Highway Authority Comments on BBUG response to 20/01830/F dated 24 Aug 2020		
Section	Issue raised	Highway Authority opinion
Summary	See individual issues below	
2	Design does not meet Policy SLE4	Interpretation of the policy is a matter for CDC. However, my opinion is that the proposed design (with the changes I have requested in my response) offers high quality, safe pedestrian and cycle infrastructure which will encourage walking and cycling by all users, and is suitable within the context of the location on a busy, strategic junction on the edge of Bicester.

Project	Title	Client
GRAVEN HILL	A41 PIONEER ROAD ROUNDABOUT GENERAL ARRANGEMENT	 Graven Hill Village Development Company Limited

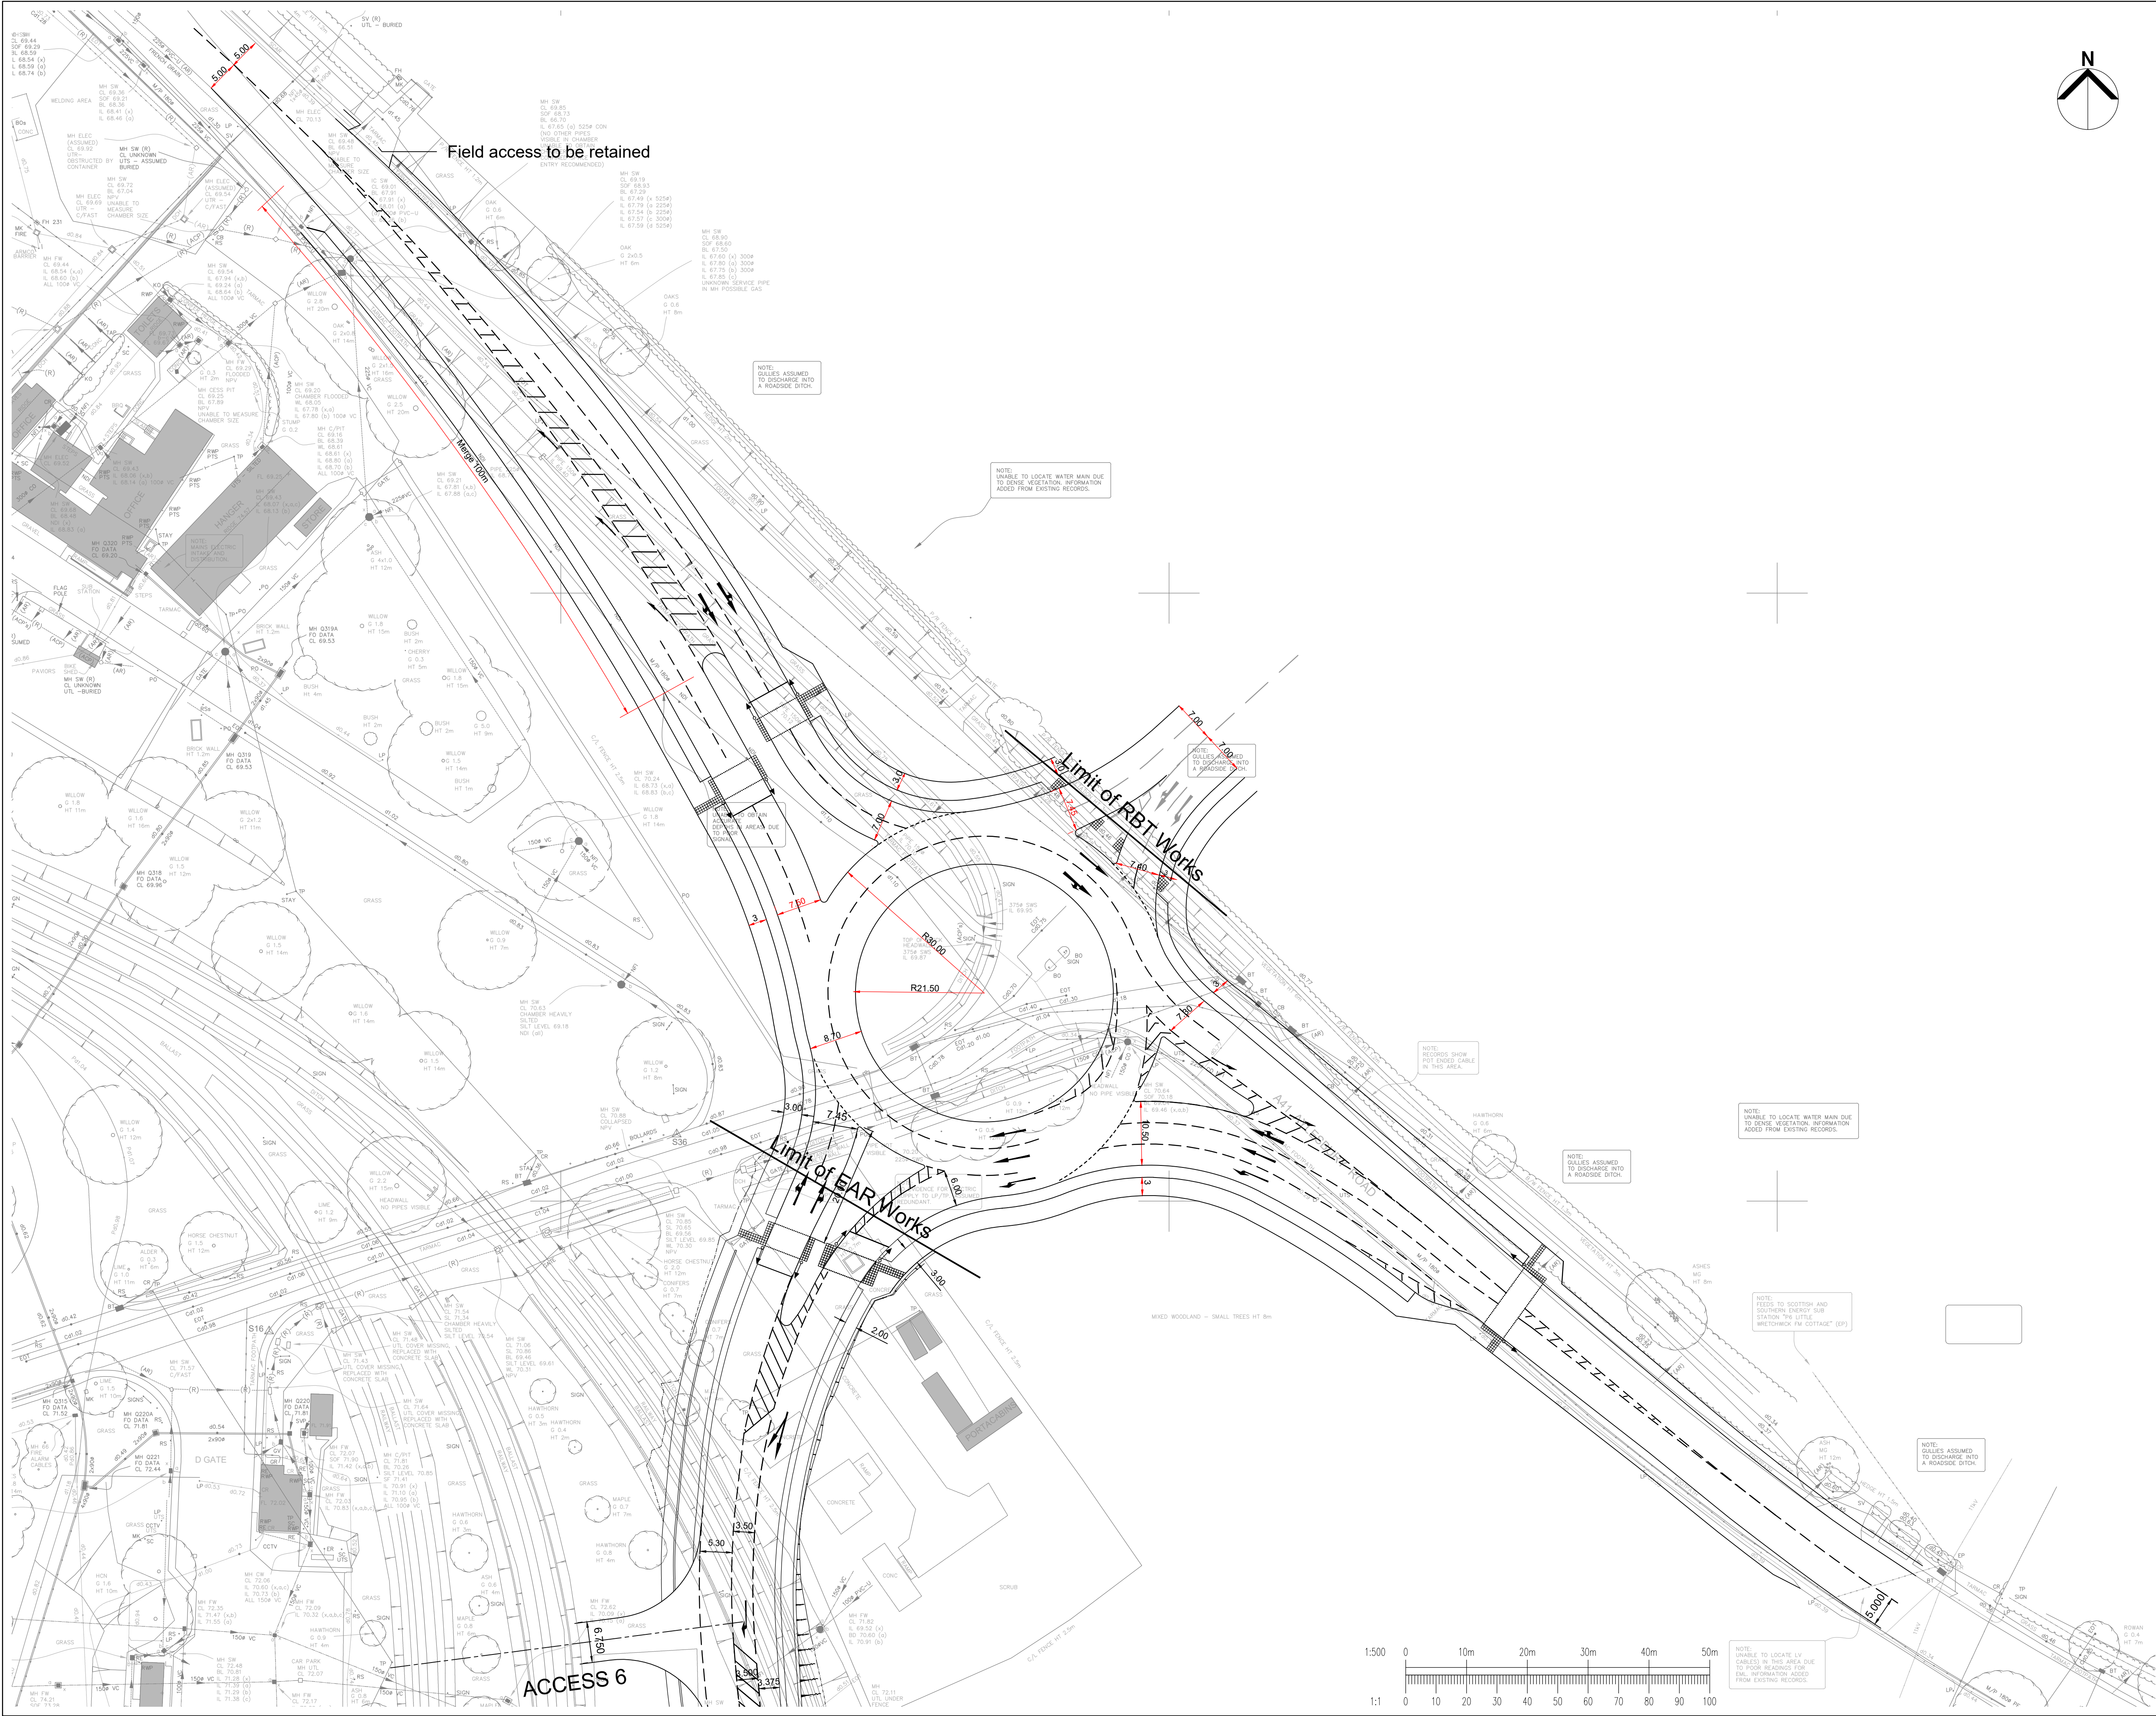
3.2	Wide, swept approaches	For safety reasons, the geometry of the proposed roundabout has to take into account the current speed limit, which is 50mph (this is not to say that it is expected people will drive at 50mph around the roundabout – it is about what realistic speed they can and will reduce to on the approach to the roundabout). The width of the approaches is also necessary to provide the capacity (which in my opinion is not over capacity – see above). The geometry also has to allow for the swept path of HGV movements, of which there are many in this location, and this will inevitably increase due to the expansion of the nearby Symmetry Park and the development of other employment sites at Bicester. If the design does not allow for the turning movements of these vehicles, kerbs will be overrun, causing maintenance and potential safety issues.

3.2	Crossings at considerable distance from natural desire lines.	The crossing on the A41 E arm is distant from the desire line, because it would be unsafe for it to be closer to the roundabout due to the three-lane eastern approach. The three lanes are necessary to provide adequate capacity for traffic flows turning left onto the future strategic link road. (Again, we will want to encourage drivers to use this new road in preference to driving through Bicester on the A41). It is also likely that this arm will have lower demand for crossing than the other arms, given the location of the residential element of Graven Hill northwest of the roundabout. The signalised crossings on the other arms are 20-25 m off the desire line, and I have asked for consideration to be given to removing the stagger on the A41W arm crossing. A 50m detour would represent only a few seconds for a cyclist and less than a minute for a pedestrian. The signalised crossings cannot be closer to the roundabout, for safety reasons. The author correctly explains that signalised crossings are the only acceptable type of crossing for the speed limit. This is a scheme that a developer proposes to introduce on the existing network, and as explained above, it has to be designed for the current speed limits as it cannot be assumed that the speed limit can be reduced from the current 50mph to 30mph, which would allow for a different design.

3.2	Straightening the approaches to the roundabout, tightening	Straightening the approaches to the roundabout would have safety implications within the current setting as it would allow drivers to approach too fast. Constraints to the geometry would reduce the capacity of the roundabout, which is undesirable as explained above, and within the current setting, could have safety

geometry, and introducing zebra or parallel crossings instead of signalised	implications. LTN 1/20 Table 10-2 sets out that zebra or parallel crossings are not suitable for speed limits over 30mph.

3.2	Crossings that would permit cyclists to cross carriageways in one movement rather than two.	The E and S arms would allow for this. I have asked for this to be considered on the A41 W arm.

3.2	Requirement for segregated paths in accordance with LTN 1/20	I have objected to the proposed design on this basis – it needs to be brought into line with LTN 1/20.
4	Comments about the design process	I have already had separate correspondence with Paul Troop of BBUG on this. It's important to note the Highway Authority role in the planning process. The proposal is from the developer, primarily to provide access to Graven Hill. The developer has commissioned the design. The Highway Authority's role is as statutory consultee in the planning process. In the course of providing preapplication advice I became aware of BBUG's concerns, and advised the applicant to give them consideration by testing proposed layouts. Because the Highway Authority could not insist on this, and it was considered important, payment was offered for a limited, defined piece of investigative work, which the applicant's transport consultant carried out. The Highway Authority does not have any power to require the applicant to revisit the design, and we are satisfied that the proposed roundabout design is acceptable except with respect to specific elements set out in our consultation response.
